CITY OF ALBUQUERQUE

PLANNING DEPARTMENT – Development Review Services

RE: GAHP Casa Feliz (L19D073A through L19D073I).
Grading and Drainage Plan
Engineer Stamp Date: 11/18/15

CD-207

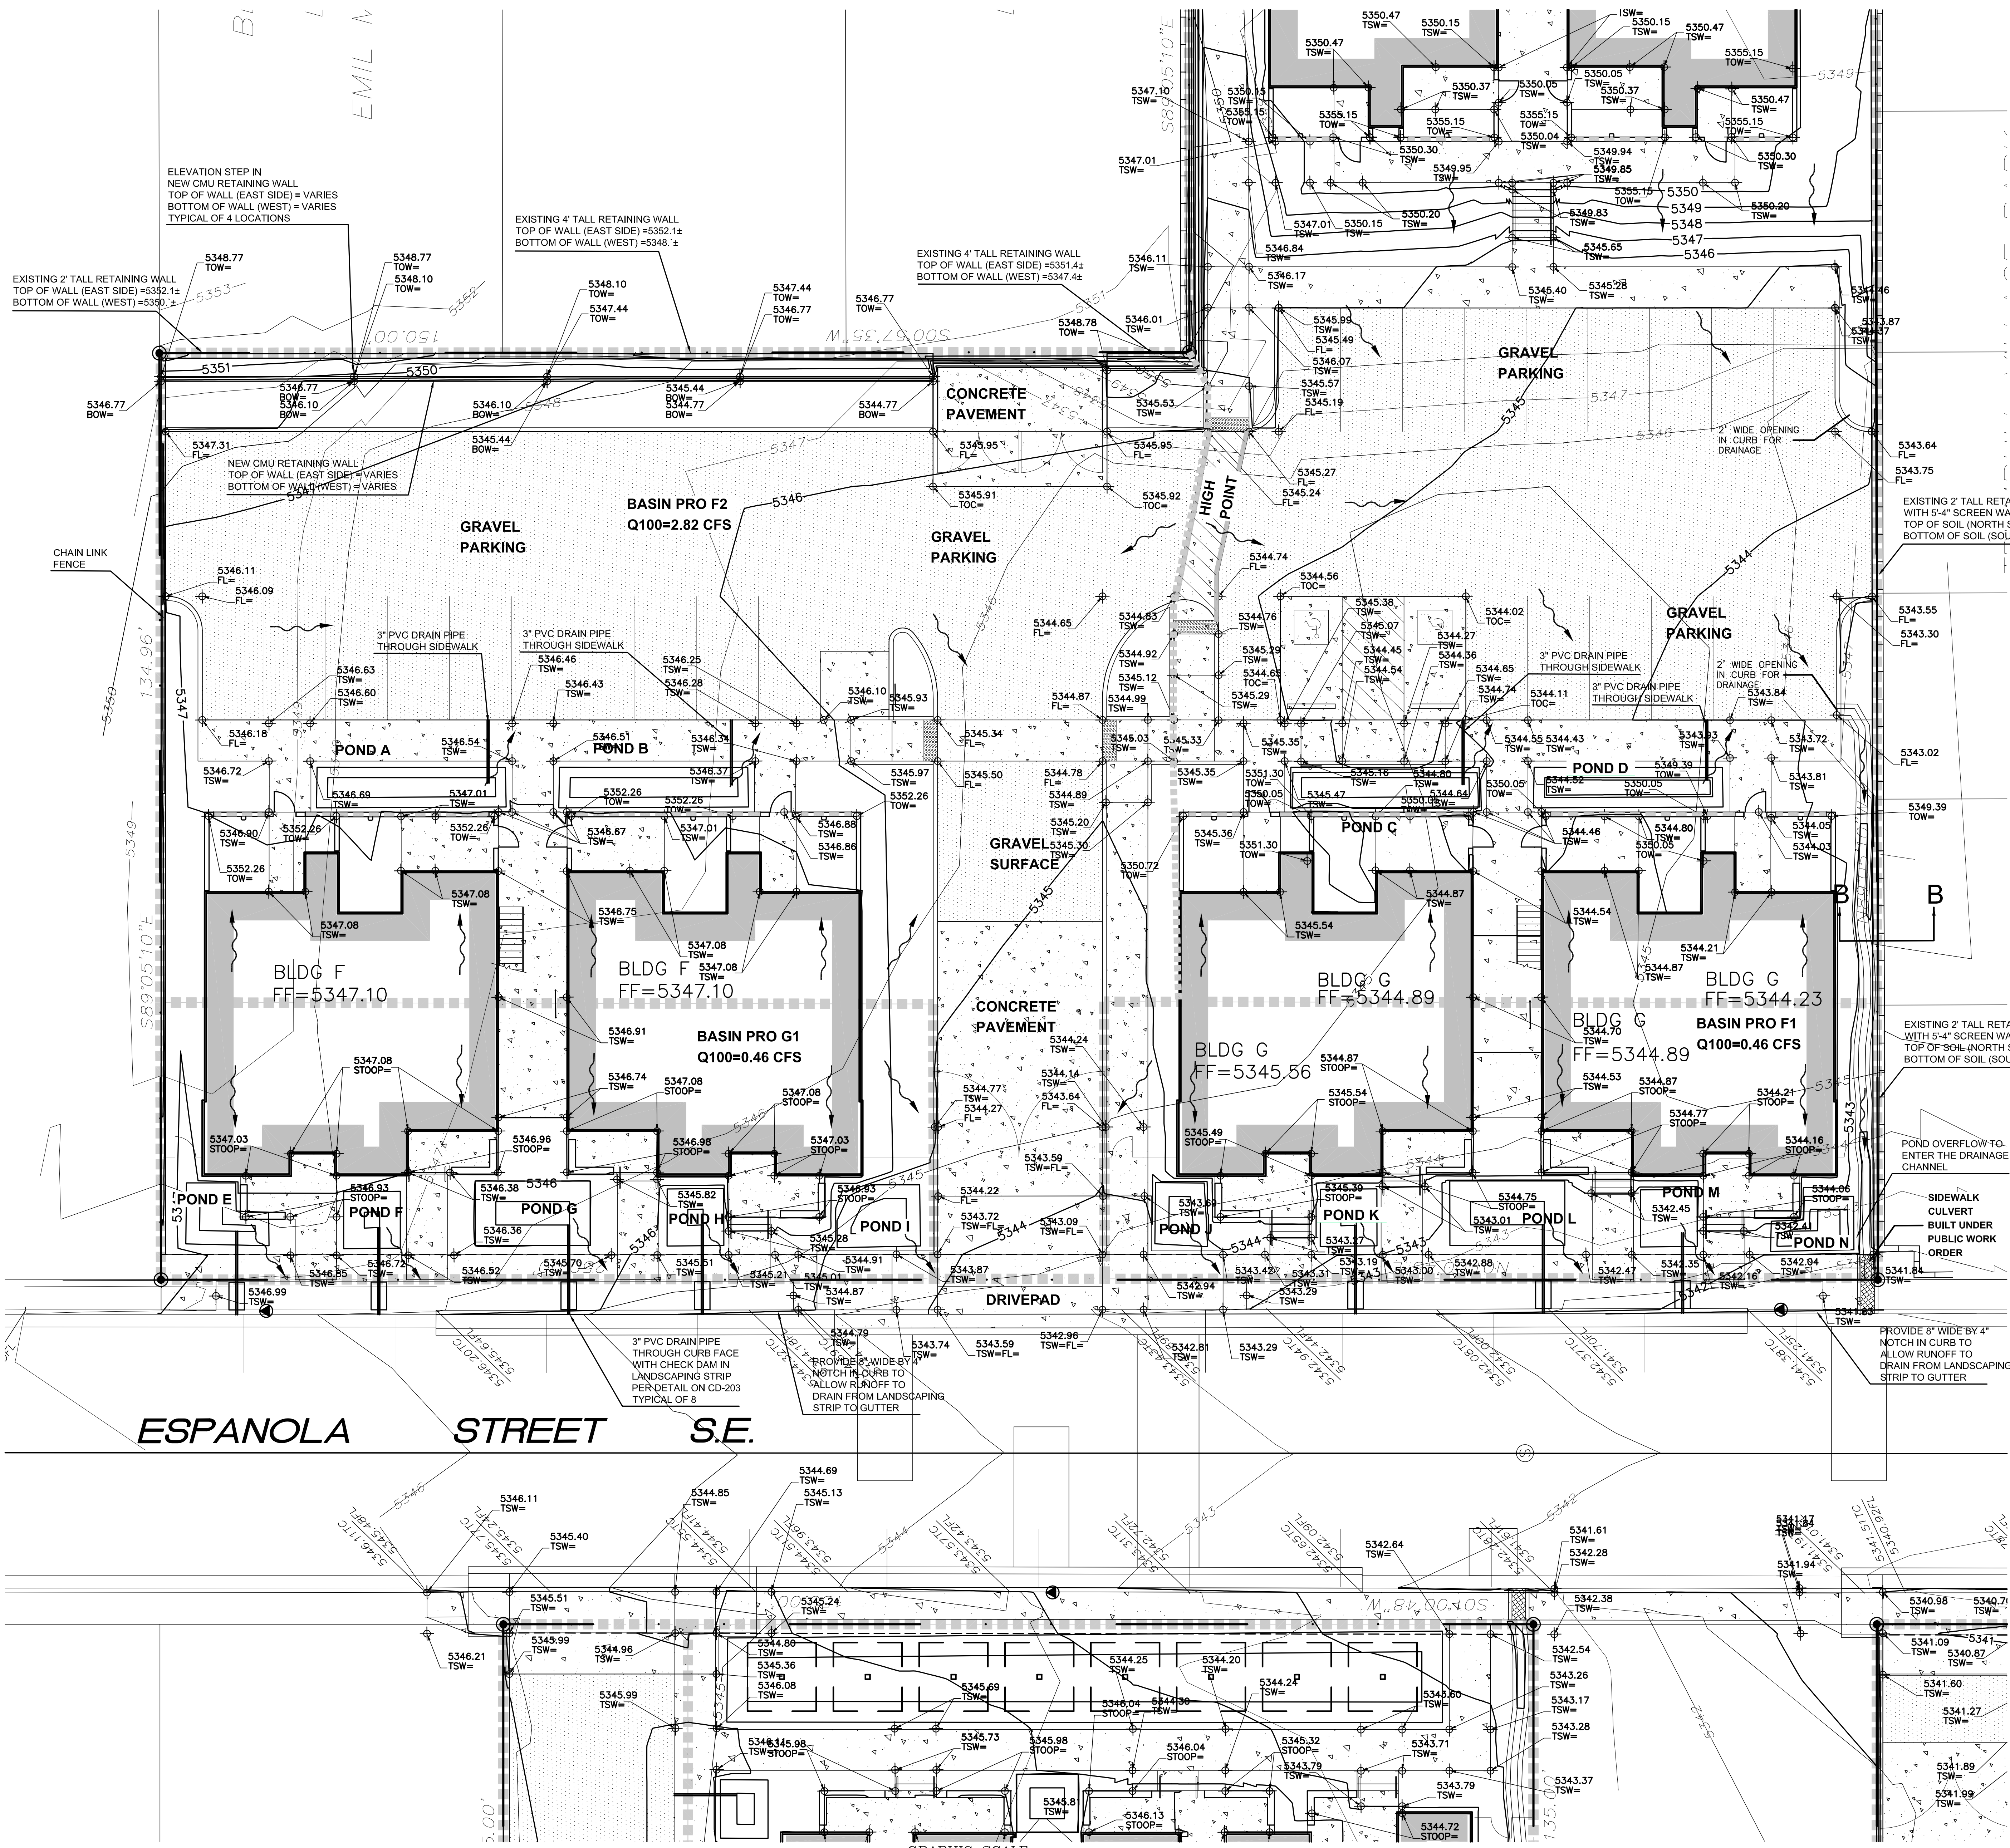
Sheet C207:

- Provide section through rip-rap channel on south side
- Remove ponding area on NE corner of site so that channel can pass to discharge to SW culvert at south end of landscape strip.
- Indicate both existing and new retaining walls (prefer to see it hatched so as to delineate it from a curb). Show TOW/BOW elevations for both.
- In front of Bldg G, shift SW culvert north so that landscape strip can discharge thru the culvert.
- Note that the SW culvert is to be constructed per work order.

A1 ENLARGED SITE DRAINAGE PLAN - BUILDING A
1" = 10'-0"

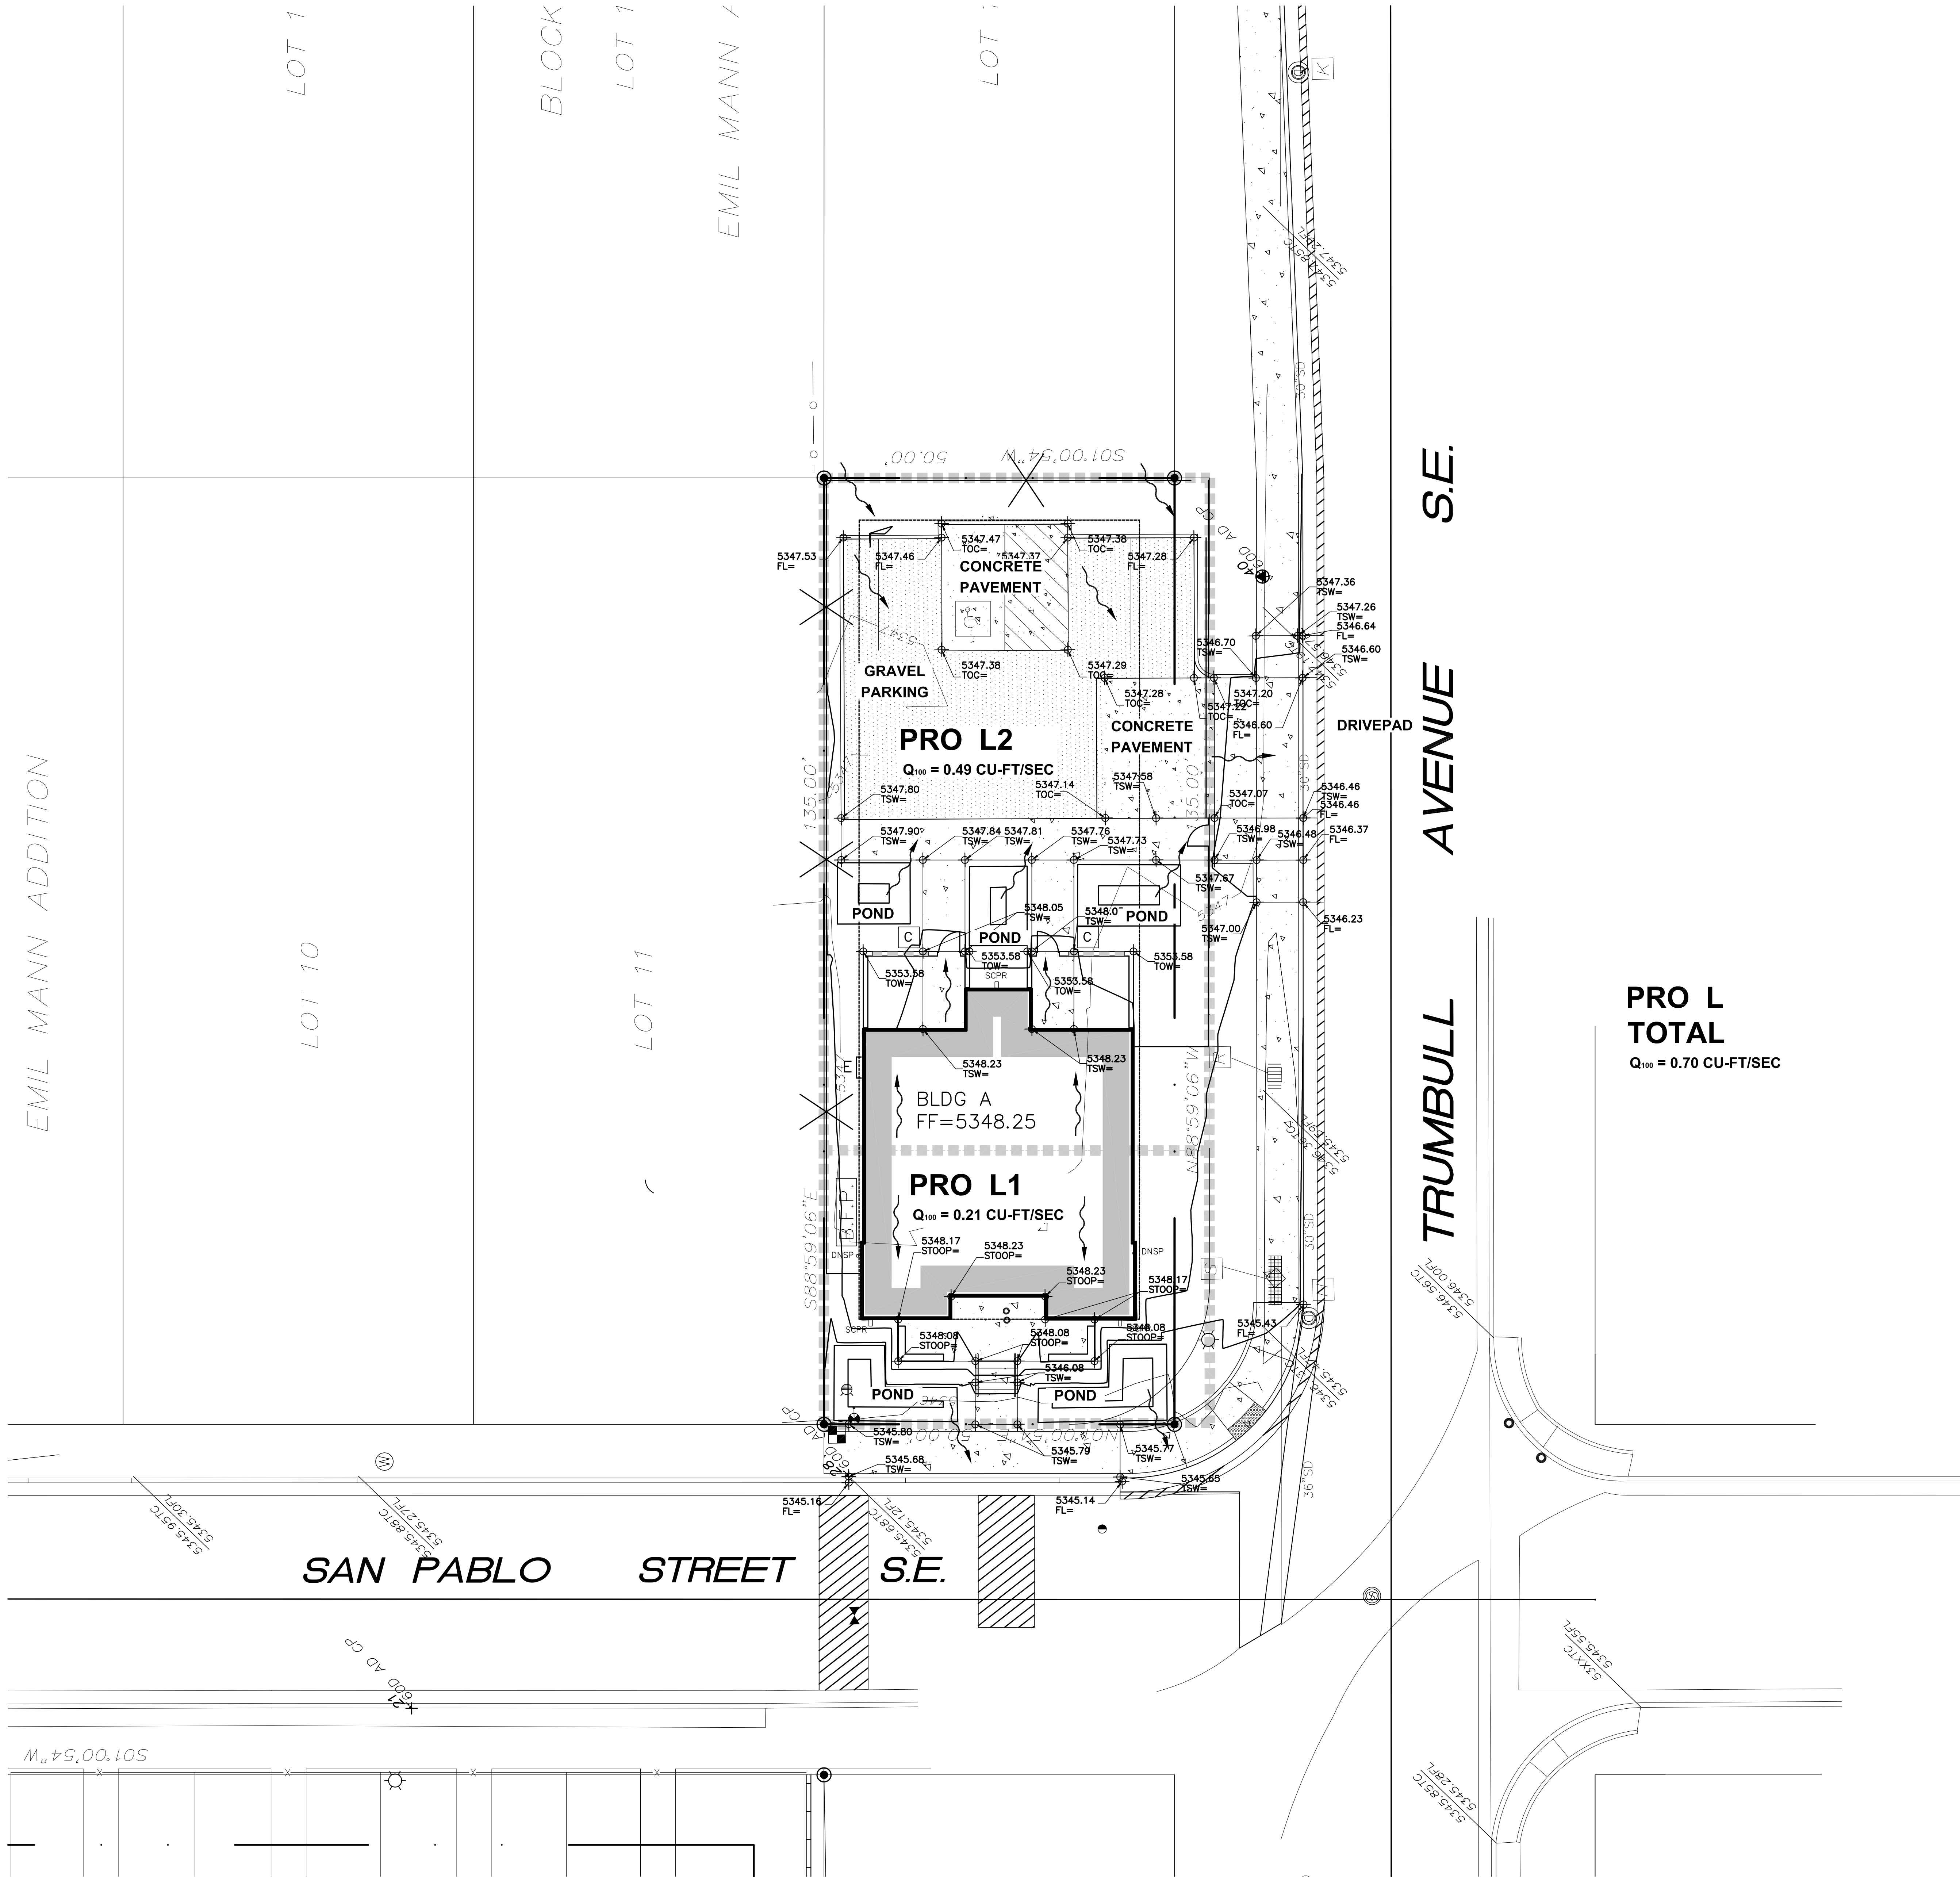
Bldg A (L19D073D, DRB # 1010671) Sheet C202:

- Show existing retaining wall on east side
- Provide outfalls for ponds as described above.
-

A1 ENLARGED SITE DRAINAGE PLAN - BUILDINGS C AND D
1" = 10'-0"

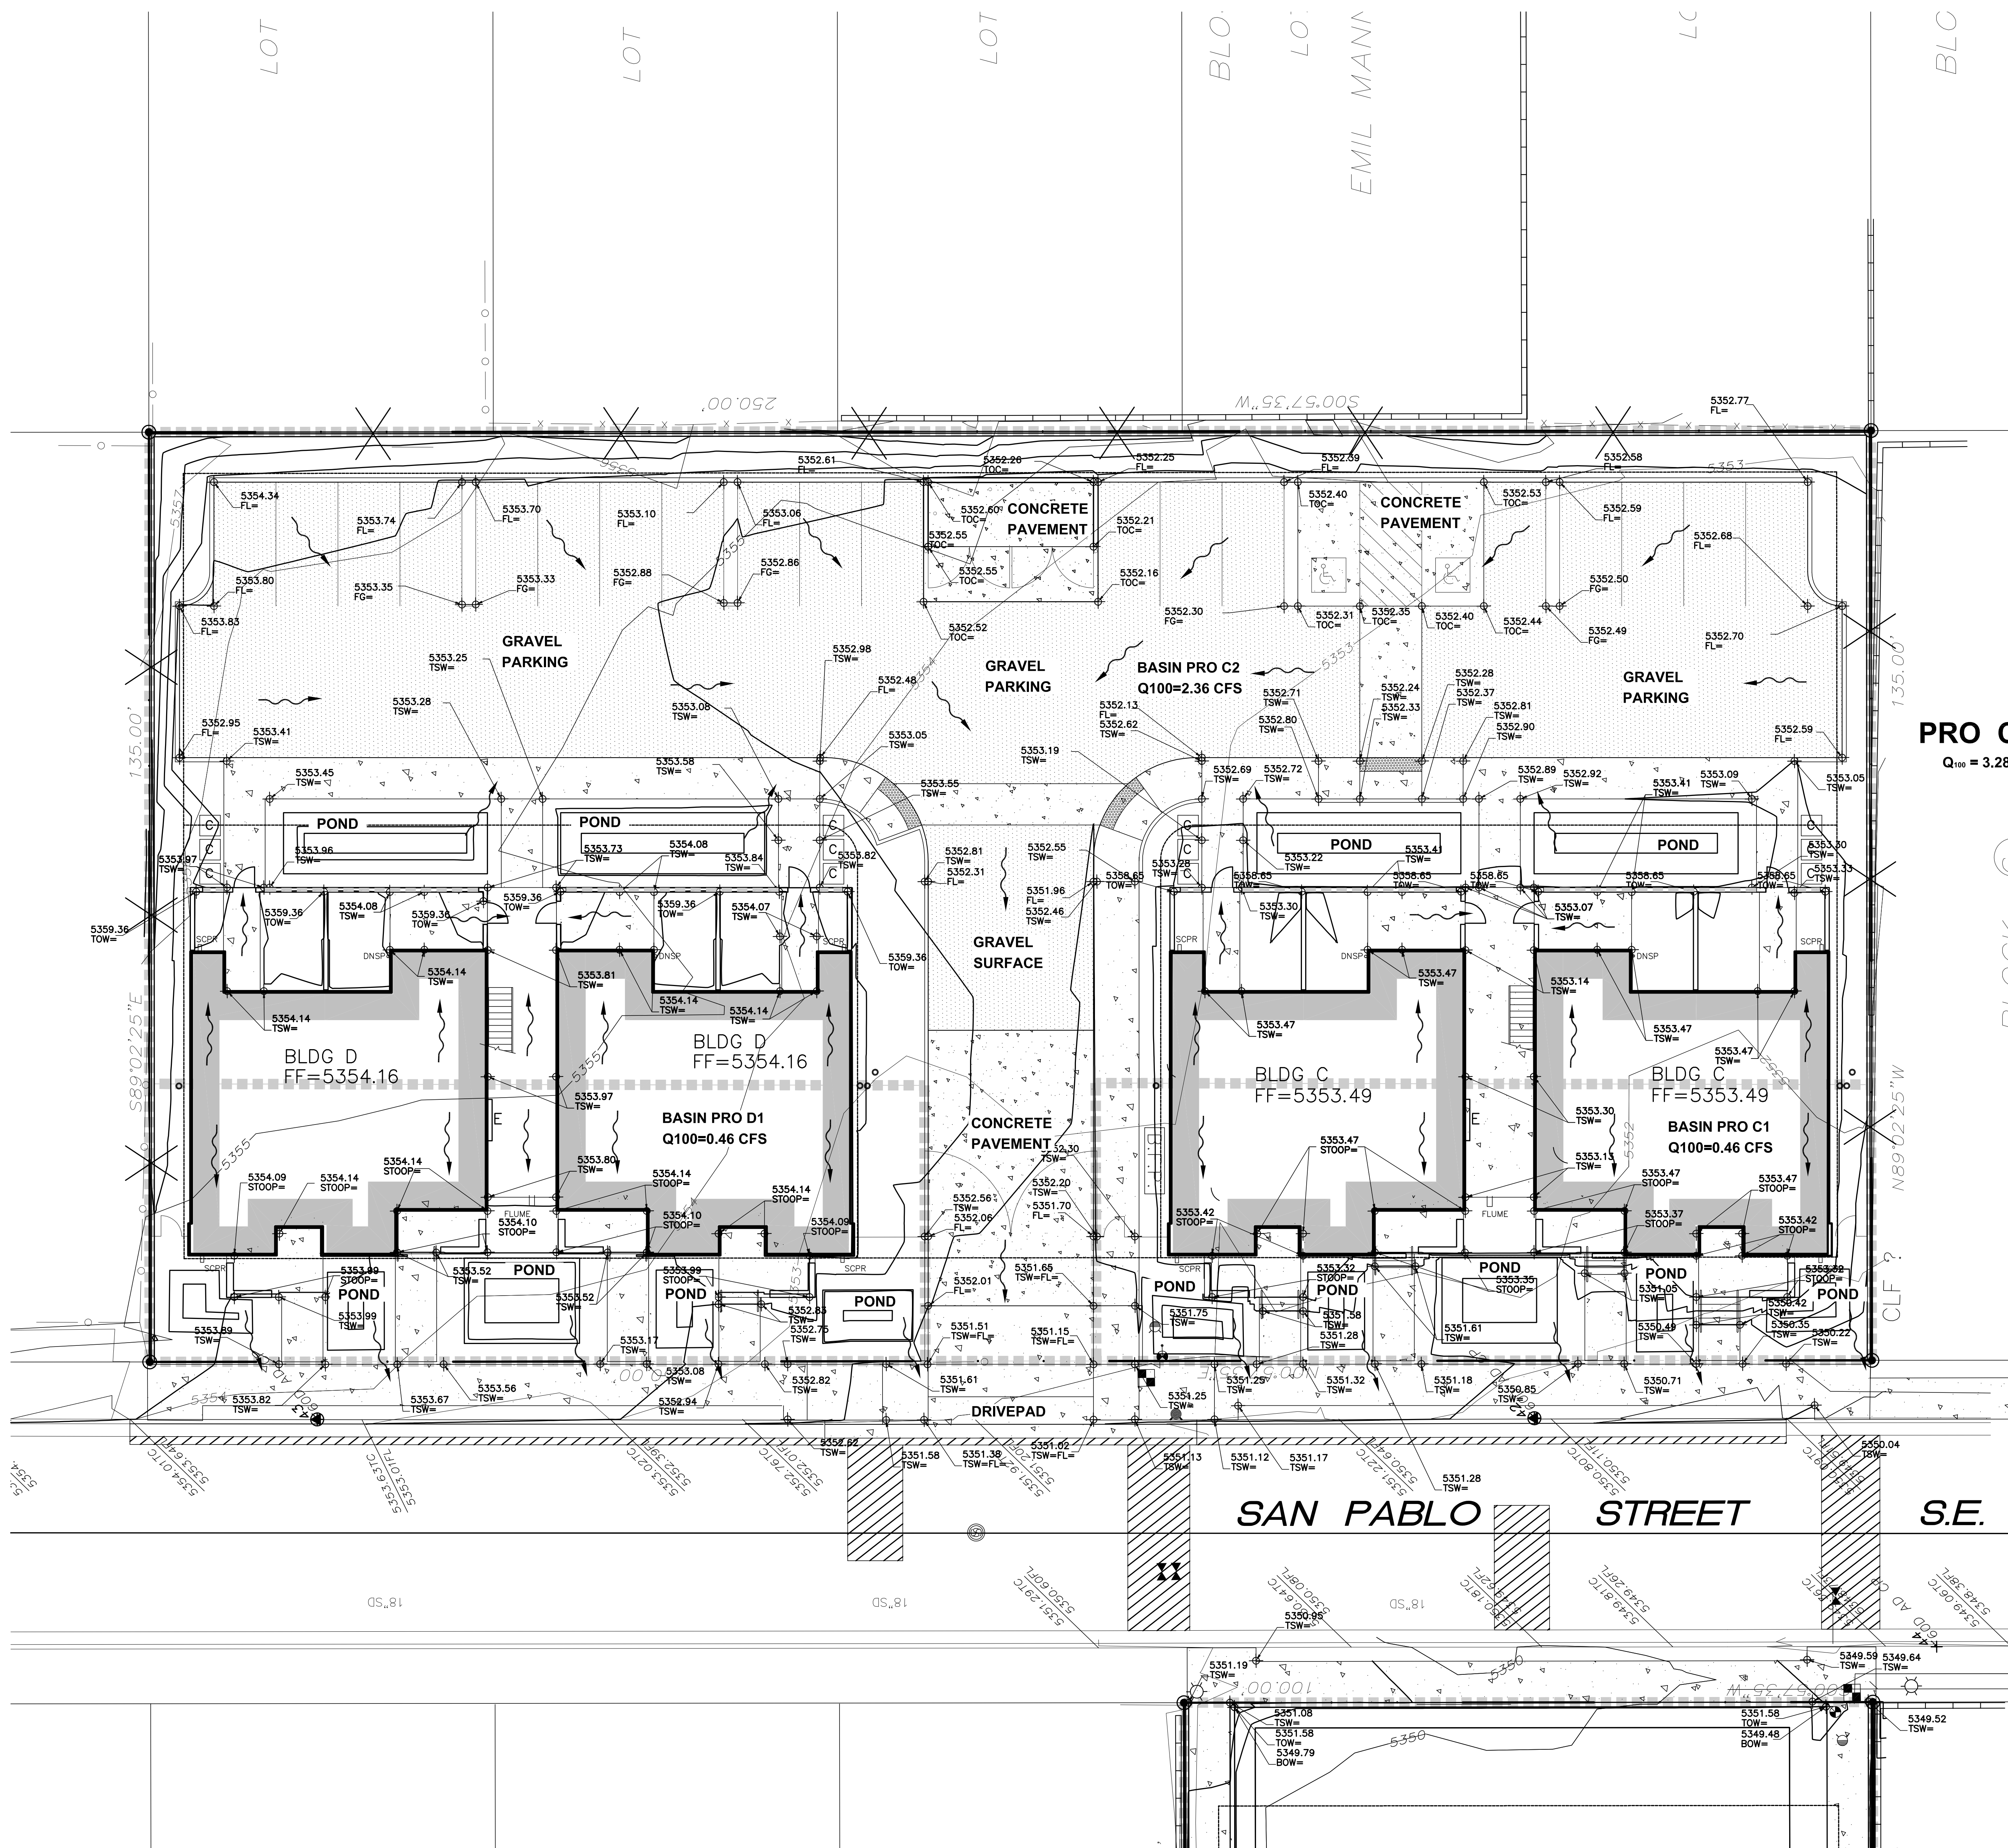
Bldg C & D (L19D073B, DRB # 1010666) Sheet C205:

- Indicate both existing and new retaining walls (prefer to see it hatched so as to delineate it from a curb). Show TOW/BOW elevations for both.
